**RE: Mister Car Wash
1020 Juan Tabo Blvd NE
Grading and Drainage Plan
Engineer's Stamp Date: 10/22/25
Hydrology File: J22D074
Case # HYDR-2025-00392**

Based upon the information provided in your submittal received 10/30/2025, the Grading & Drainage Plans are not approved for Building Permit. The following comments need to be addressed for approval of the above referenced project:

<b>MISTER CAR WASH</b> <b>ALBUQUERQUE, NM</b>	DRAWN BY pm
	<b>WALL PLAN AND PROFILE</b>	DATE 1-15-26
		DRAWING
		SHEET # <b>8</b>
		JOB # 2025017

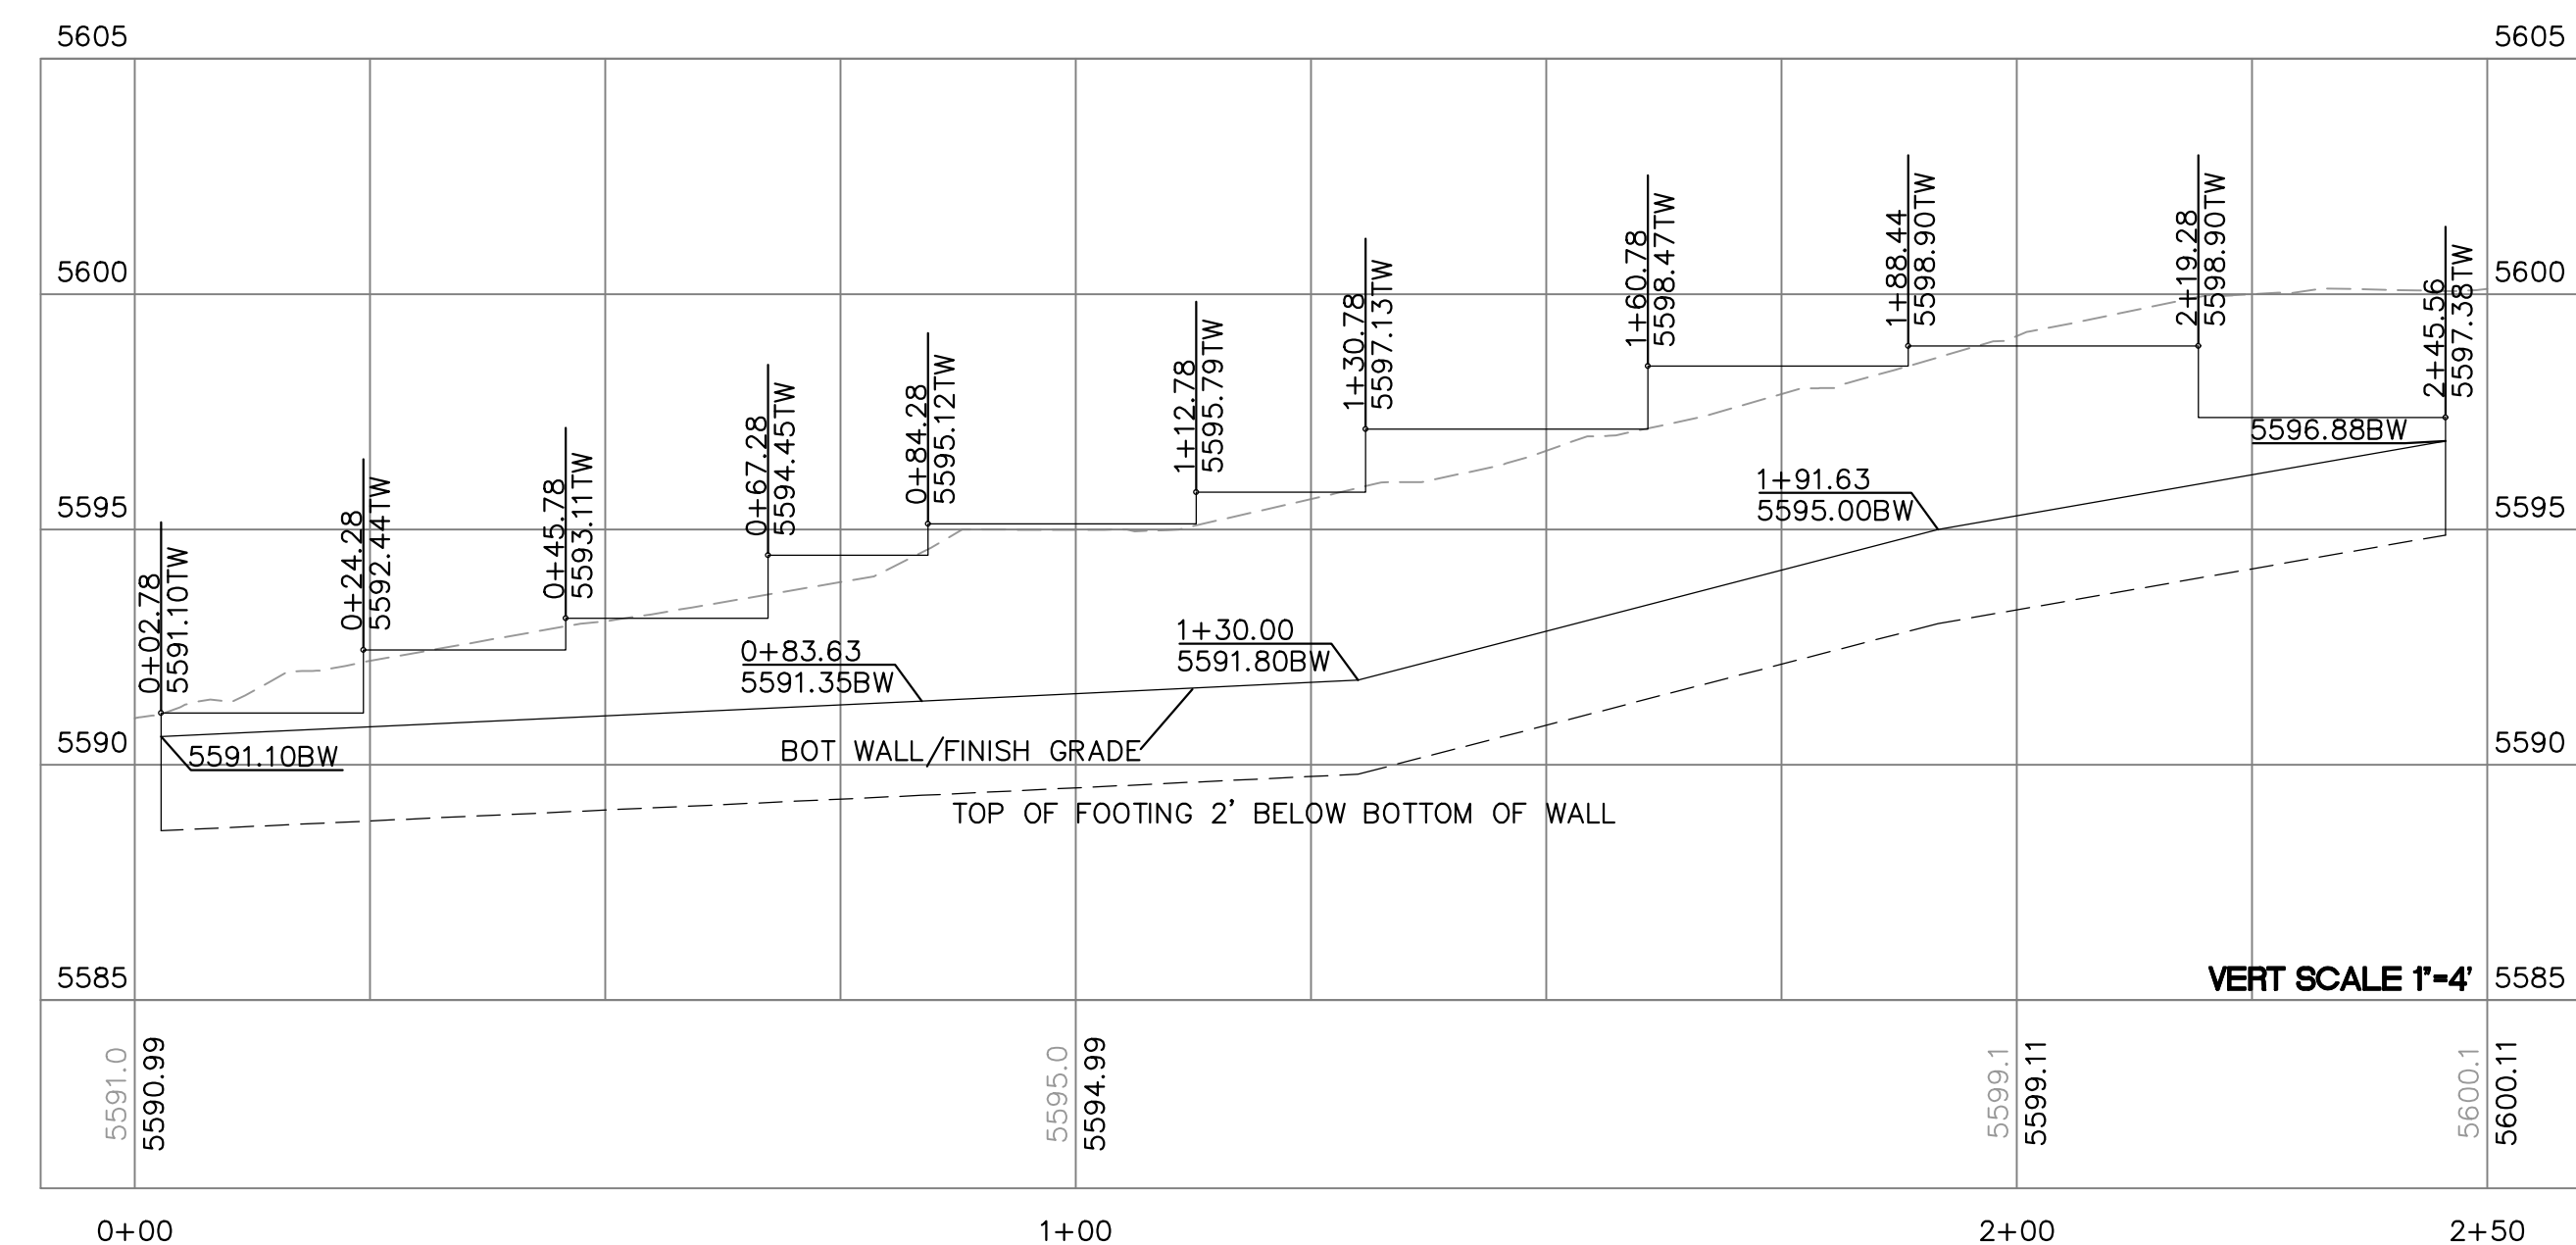
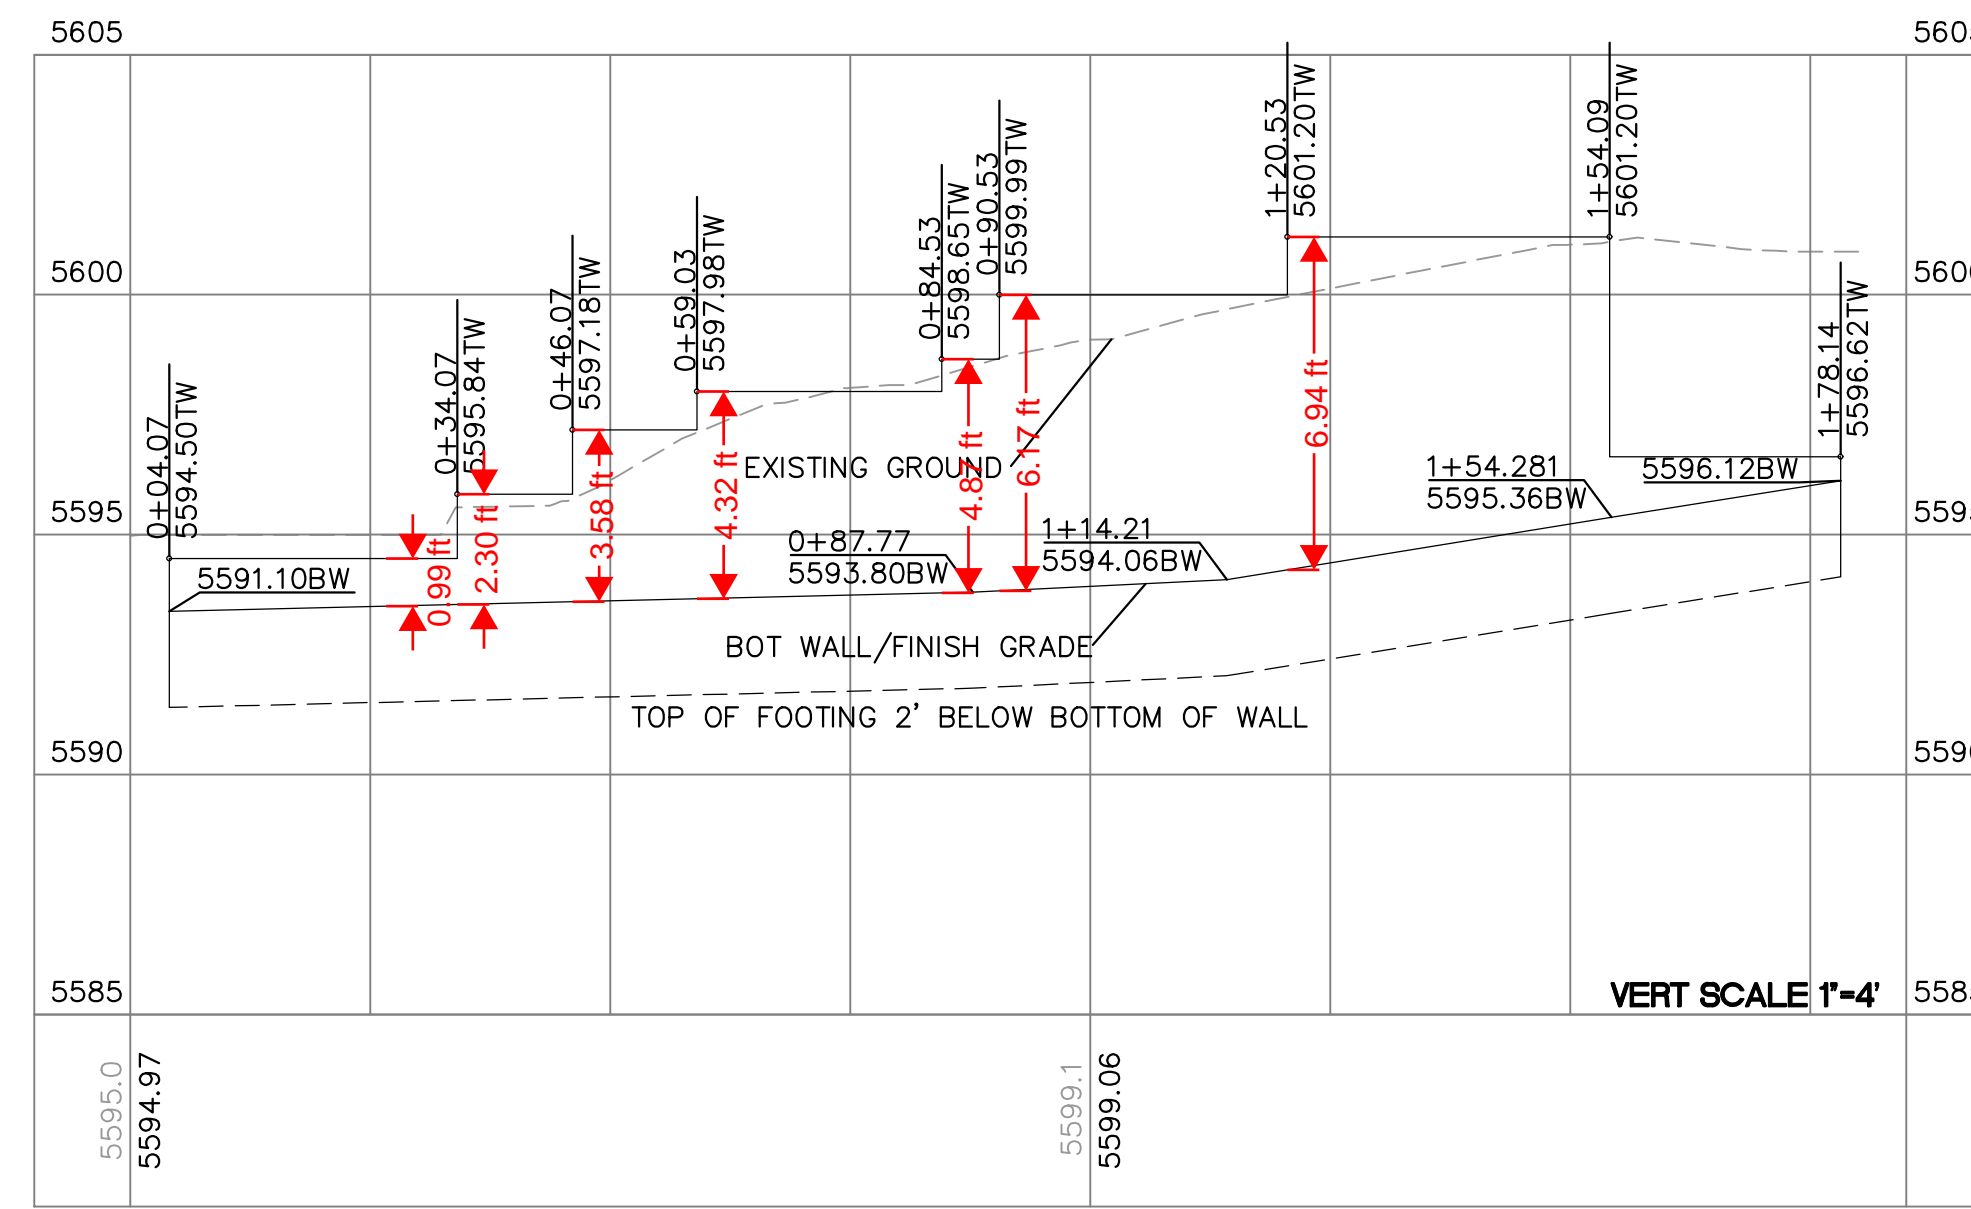
1. A portion of this project is located in a floodplain (AO-1') and a floodplain development permit must be obtained. The permit application must demonstrate zero rise to the base flood elevation, unless a Letter of Map Revision (LOMR) is being prepared. Please contact Rudy Rael, CFM for more information regarding floodplain development permits (rrael@cabq.gov or 505-924-3977).

2. Please show the SFHA boundary on the plan.
3. Please update the floodplain note with the SFHA information.
4. Please state the 100-year BFE and verify that the proposed FF elevation is sufficient.
